**KIRKLEES METROPOLITAN COUNCIL
INVESTMENT & REGENERATION SERVICE**

Reference No: 2017/62/93660/E

Site Address: 68, Daisy Hill, Dewsbury, WF13 1LS

Description: Change of use from office (A2) to 4 flats, installation of rooflights and new windows and doors (within a Conservation Area)

REV. DATE	REVISION	BY	MM
CLIENT			
PROJECT			
81-83 Daisy Hill Dewsbury WF13 1LT			
TITLE			
Proposed Plans & Elevations			
STATUS			
Planning			
DATE	SCALE		
30.09.17	1:50,200@ A1		
DRAWN BY	REVIEWED BY		
	M N Ali		
DRAWING NUMBER			
WF/07/P03

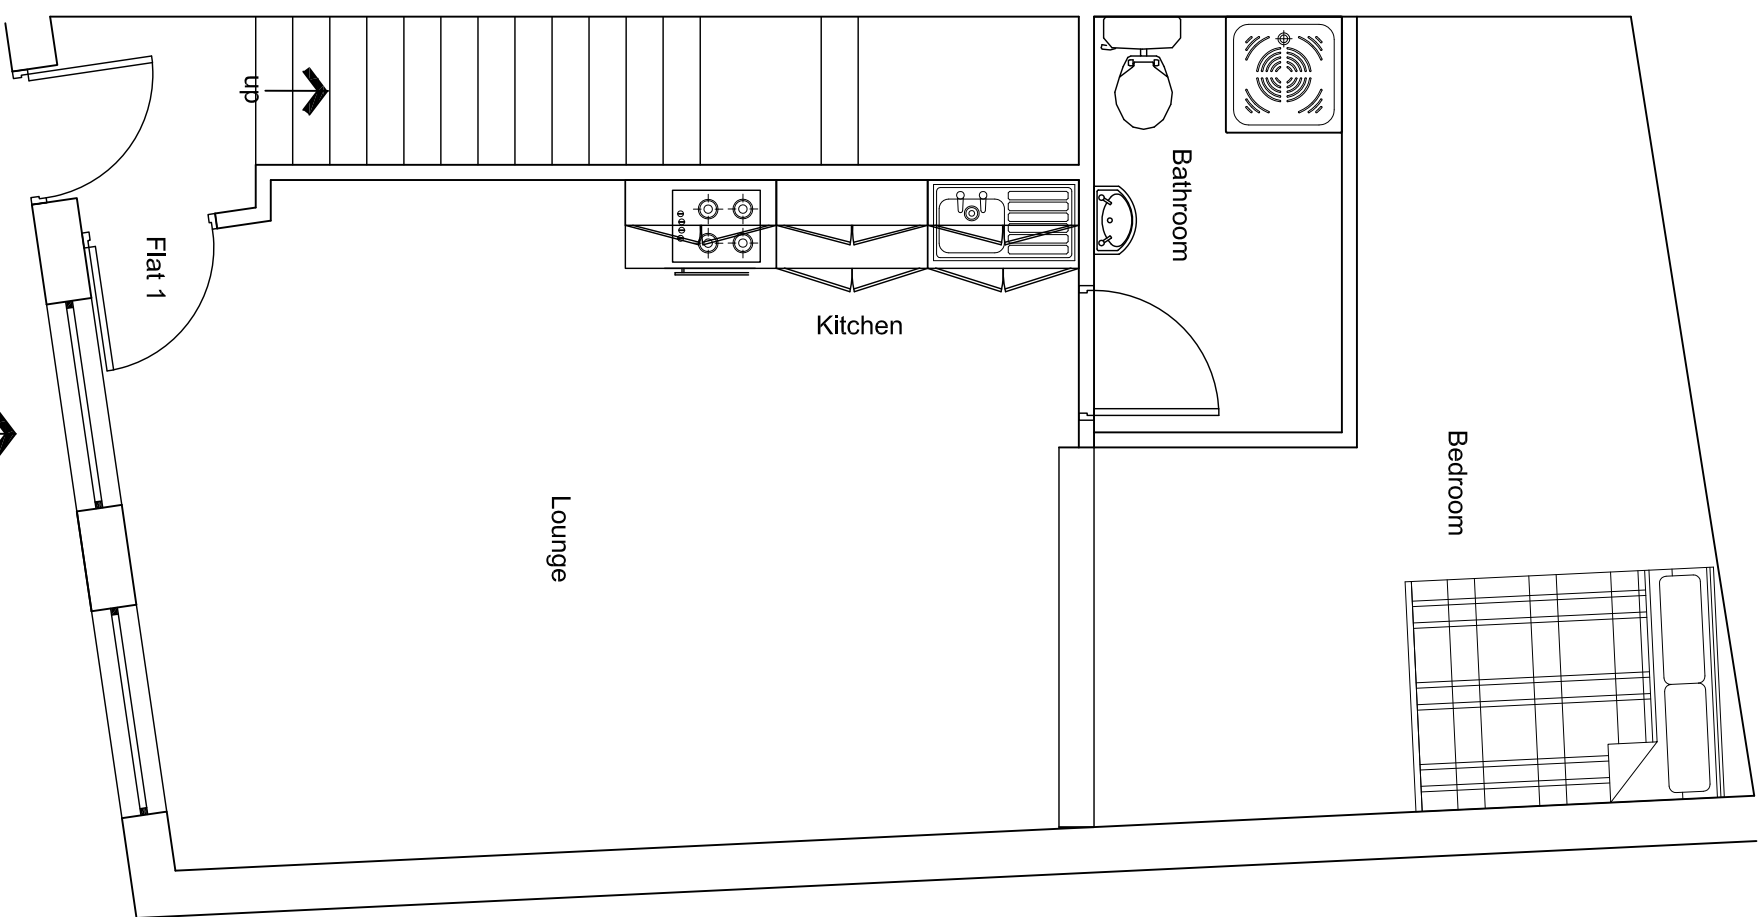
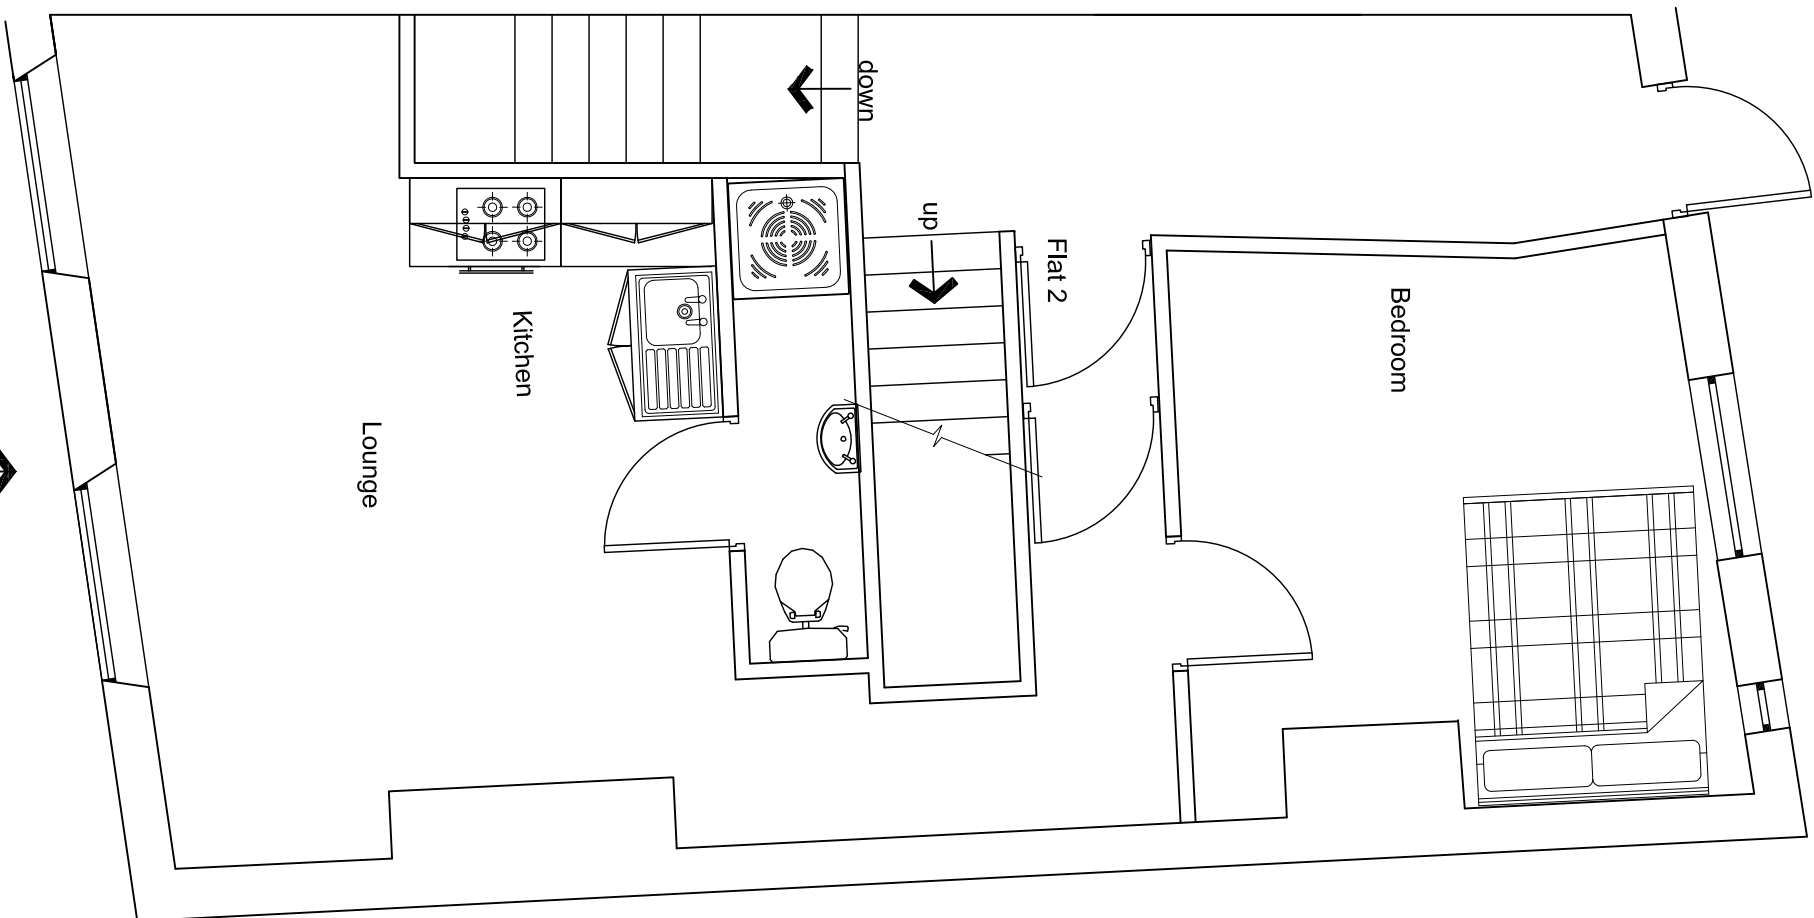
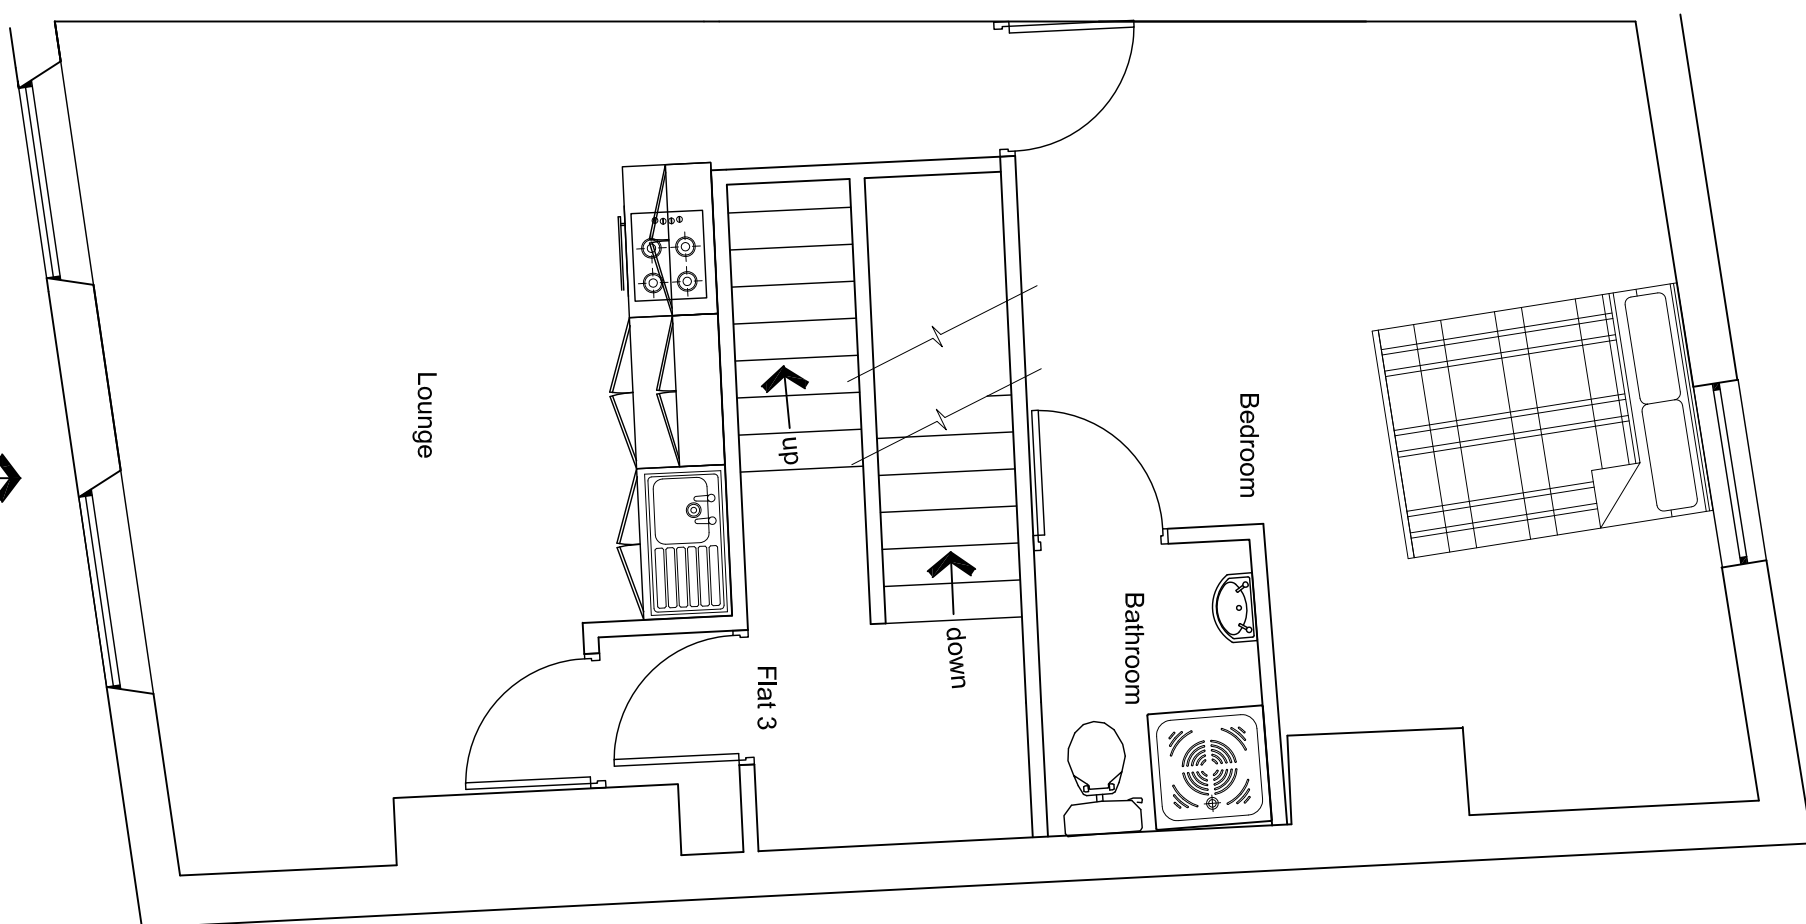
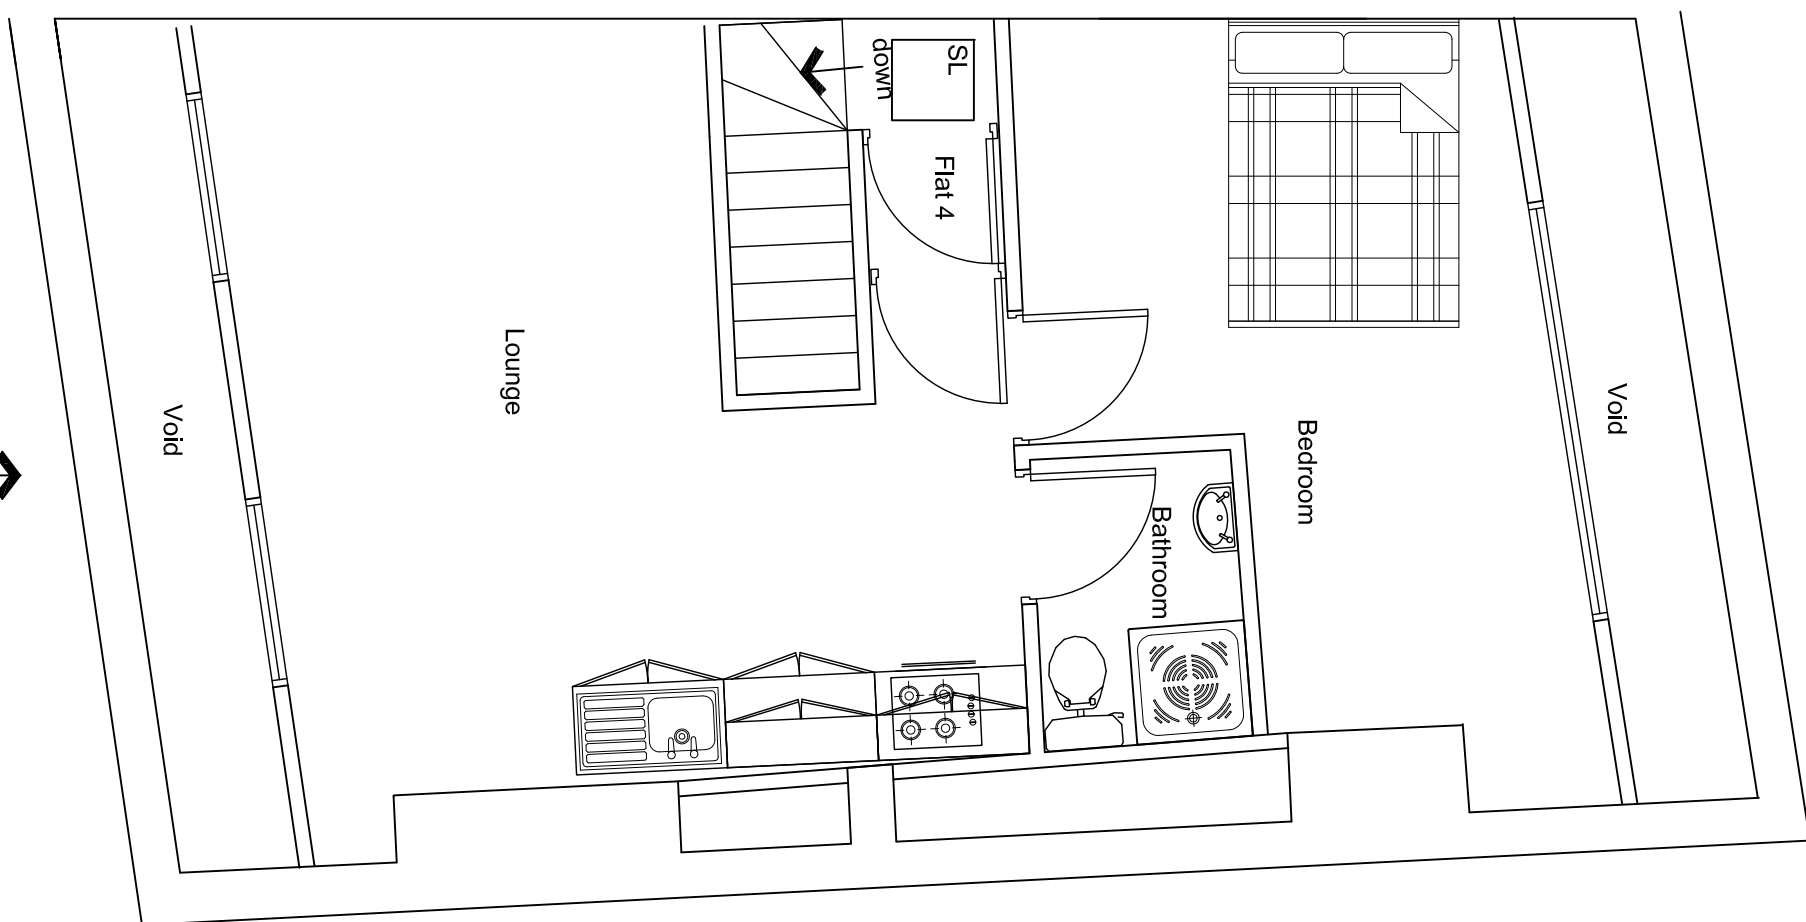
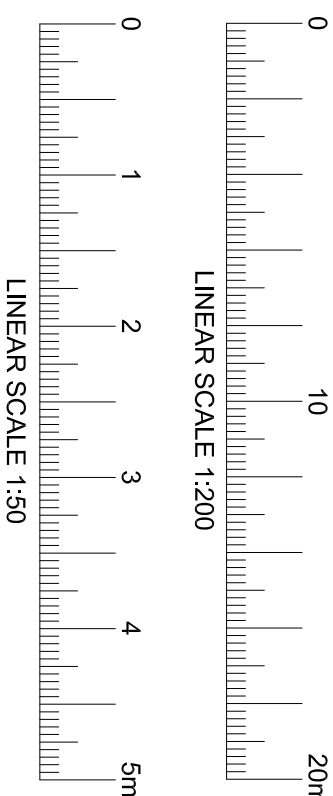
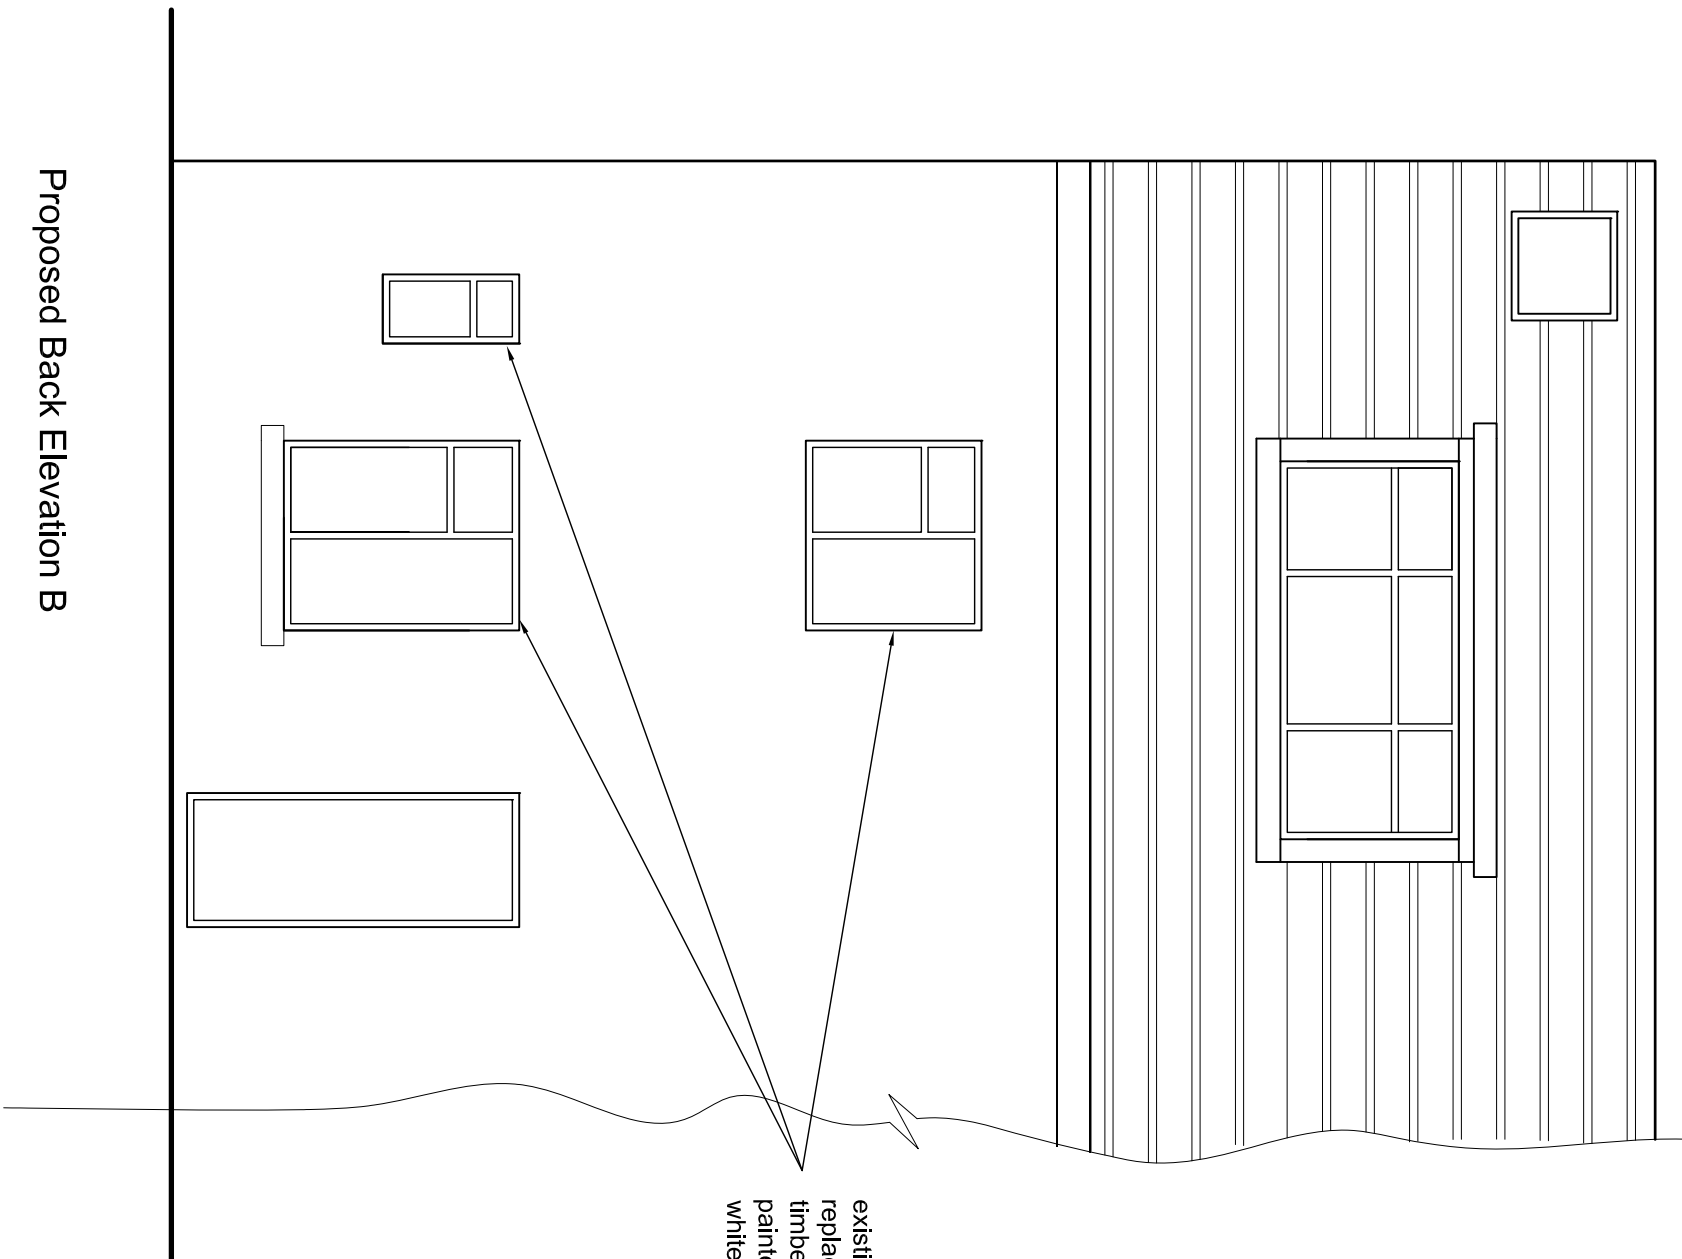
Bin storage details have been provided on the submitted plan WF/07/P03 and are considered to be acceptable from a Highways perspective, in accordance with policies D2 and T10 of the UDP as well as policies PLP21 and PLP22 of the PDLF.
